Our ref: DOC22/1002286

Your ref: SSI-10035

Subject: EHG comments on Environment Impact Statement for Parramatta Light Rail – Stage 2-SSI-10035

Subject: EHG comments on the Environment Impact Assessment for Parramatta Light Rail Stage 2 - SSI-10035

Figure 7.8 Proposed compound locations –map 1

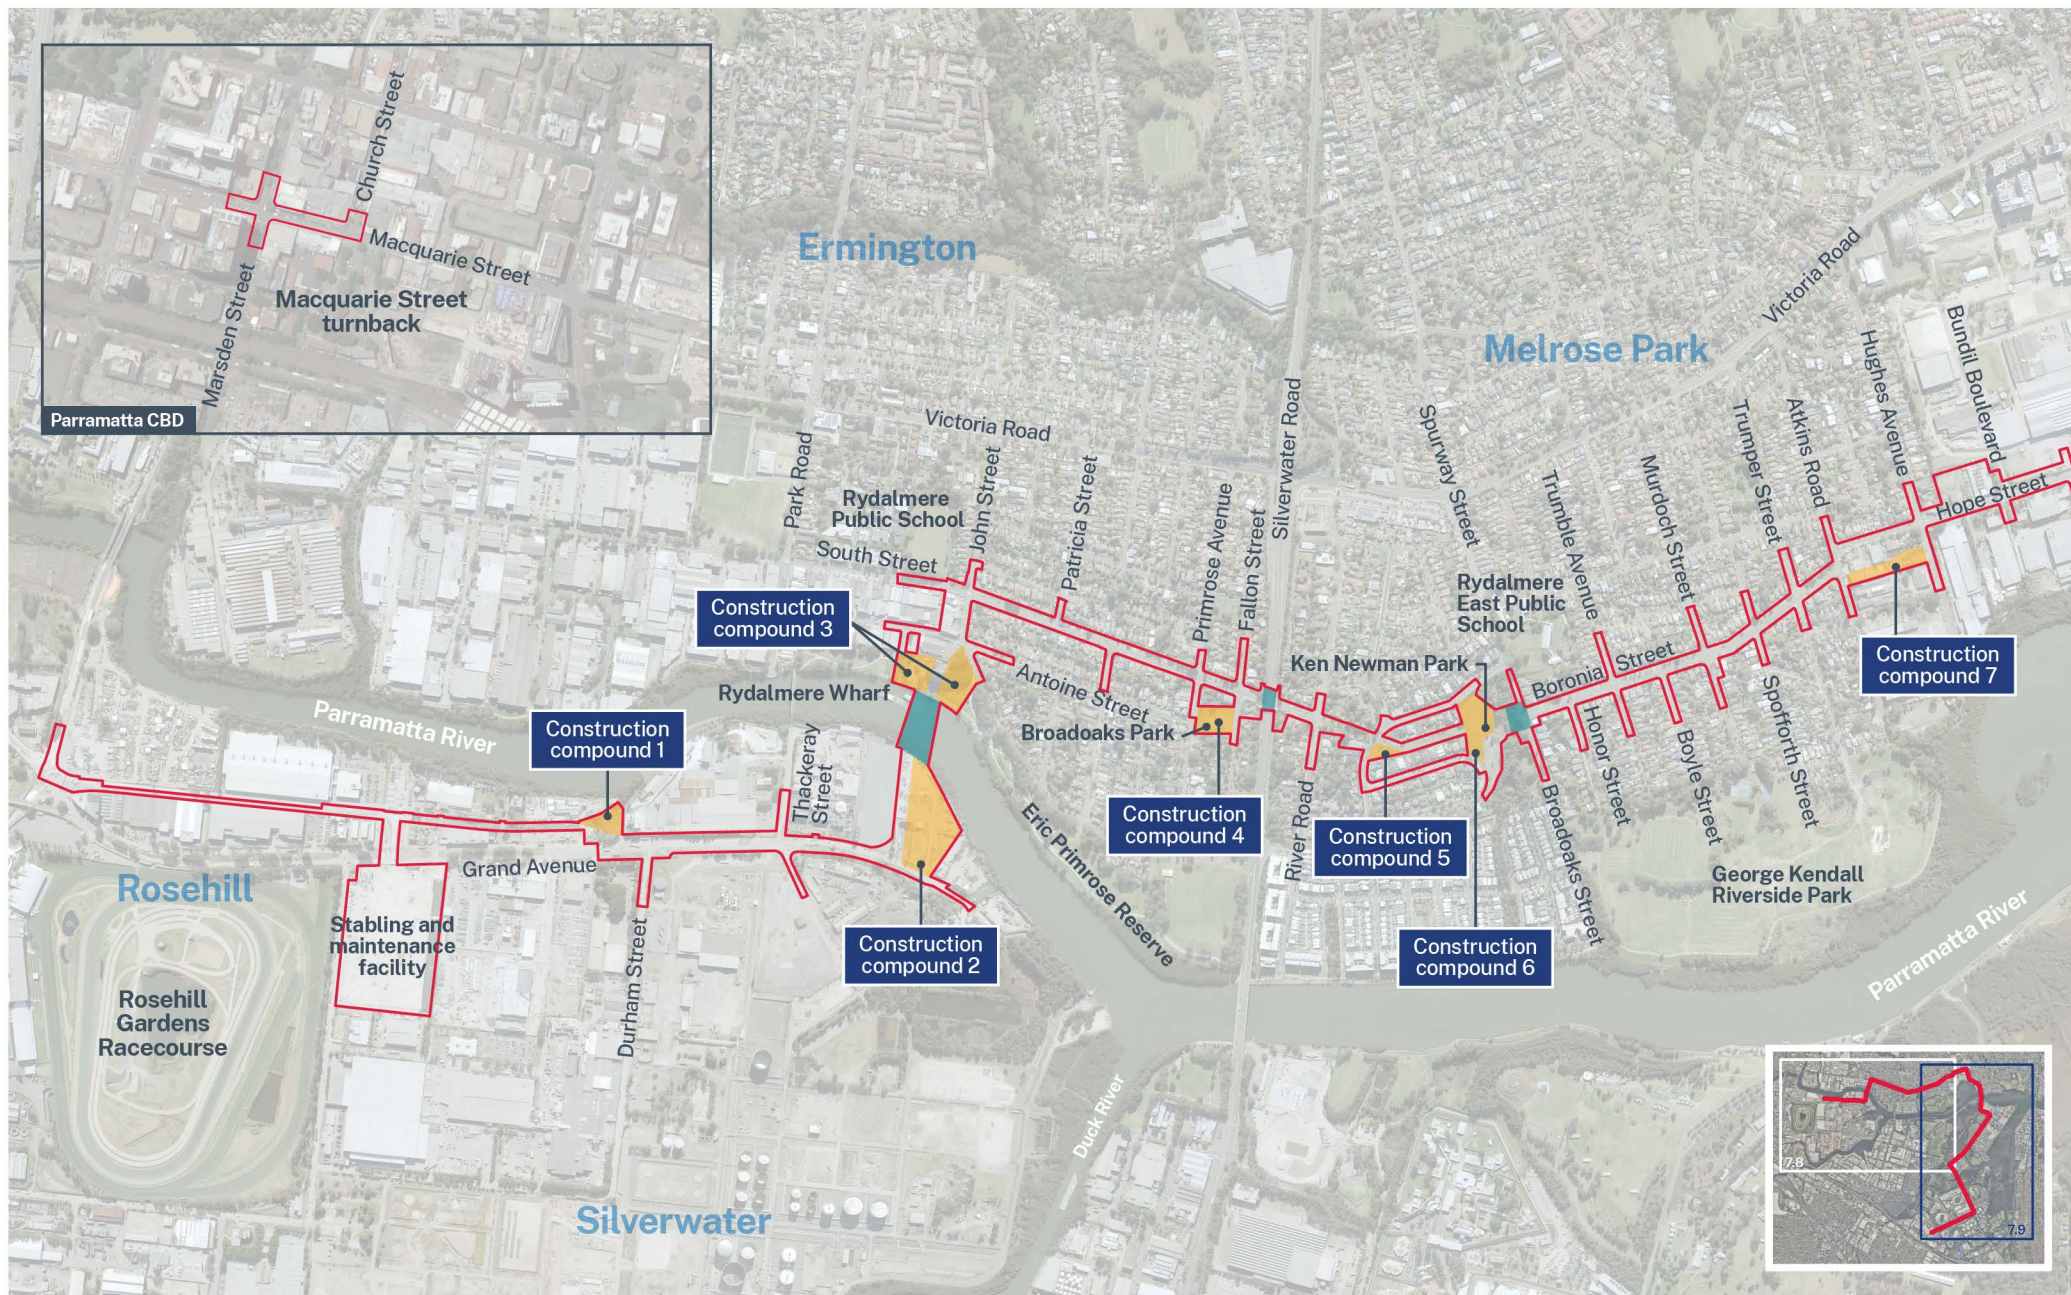
EHG recommends that when the construction compounds at the Camellia -Rydalmere crossing (compound 2 and compound 3, see figure 7.8 – map 1) and Archer Park / Melrose Park/ Koonadan Reserve - Wentworth Point bridge (compound 8 and compound 9, see Figure 7.9 – map 2) are removed, any impacted riparian land (i.e., within 40m of the Parramatta River (measured from top of highest bank)) are replanted with local native species.
